From: Amber Willard <Amber.Willard@arun.gov.uk>
Sent: 15 July 2020 09:35
To: Planning.Responses <Planning.Responses@arun.gov.uk>
Subject: FW: AL/23/20/HH

Subject: RE: AL/23/20/HH

Proposed First Floor Plan

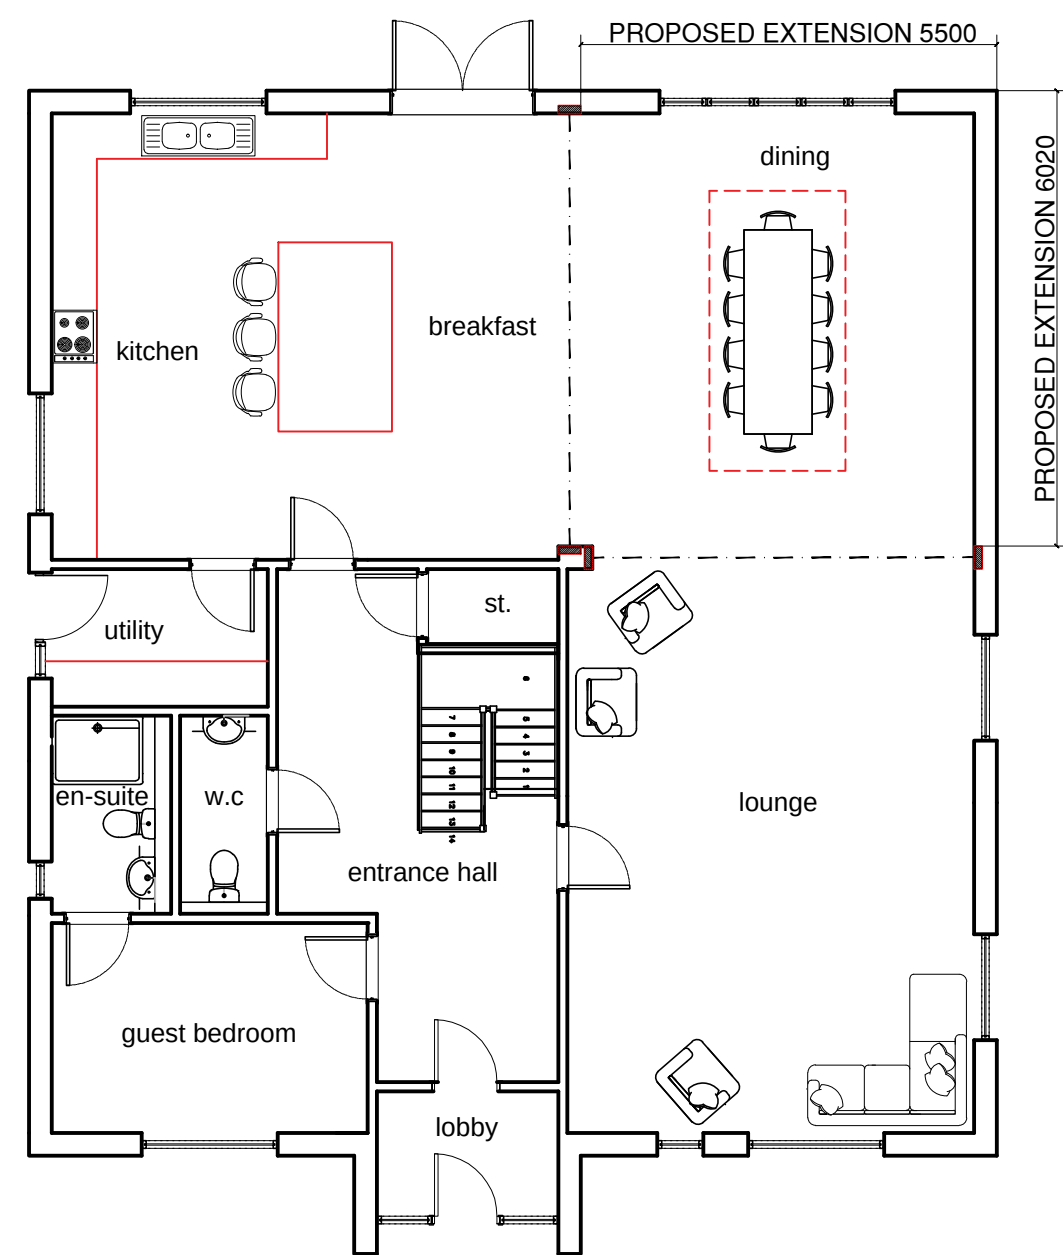
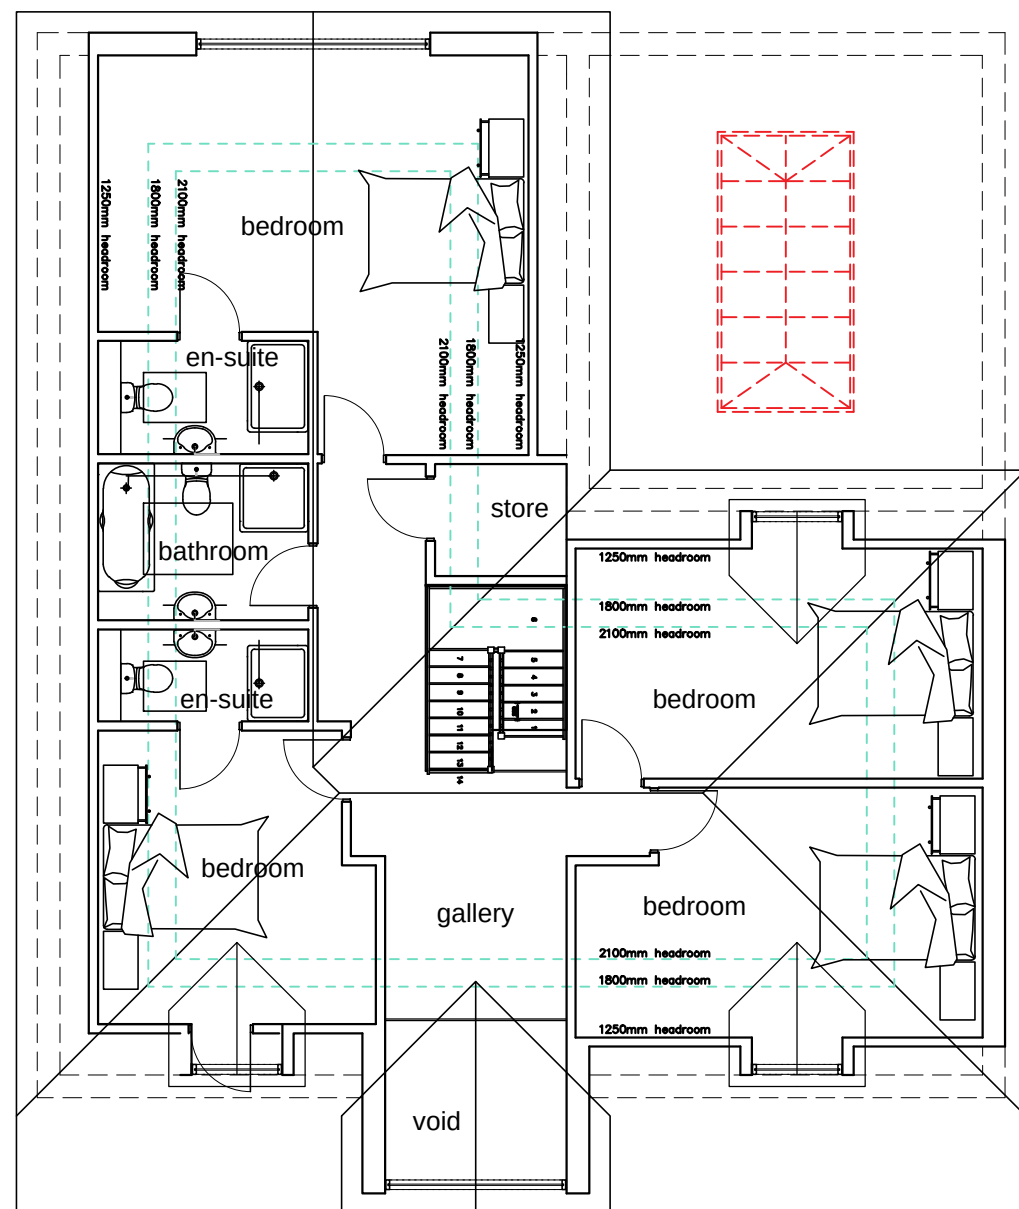
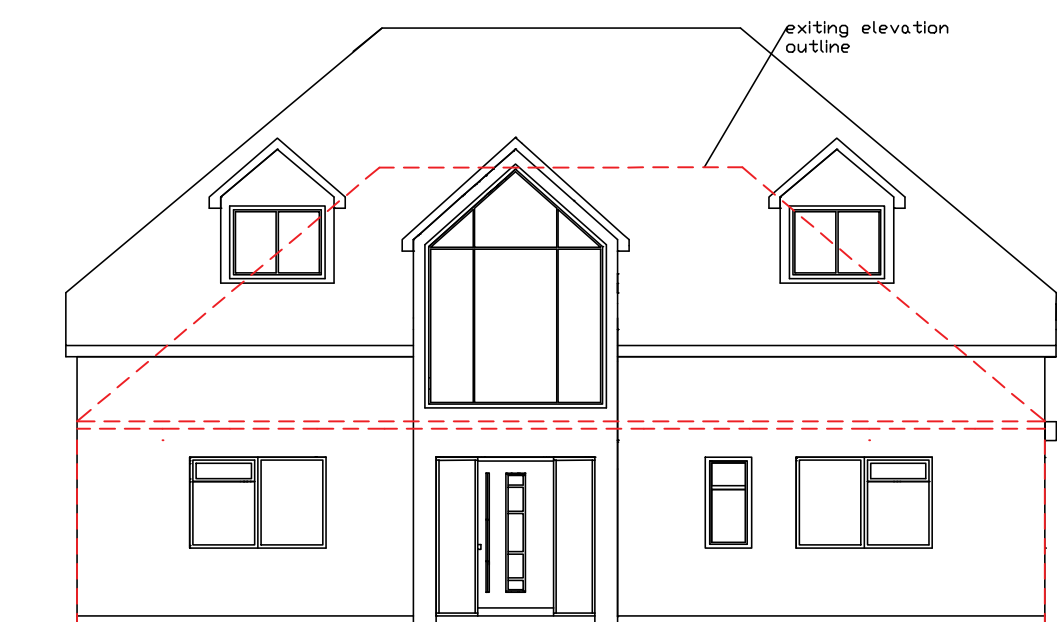
My concern is around the potential for overlooking from the bedroom facing to the rear above the single storey element. I attach a 'photo which shows the current building in relation to the neighbour that would be overlooked. Can you suggest a solution to overcome this?

IN regard presenting an amendment, we will need at least 24 hours to do so, but the only solution to retain this bedroom which is fundamental to the clients scheme for his family, is to replace the dormer with a rooflight, whilst in this location there will be some overlooking with a bedroom, we would assume this is relative to the surrounding area and a rooflight would minimise this rather than a dormer which projects slightly further forward.
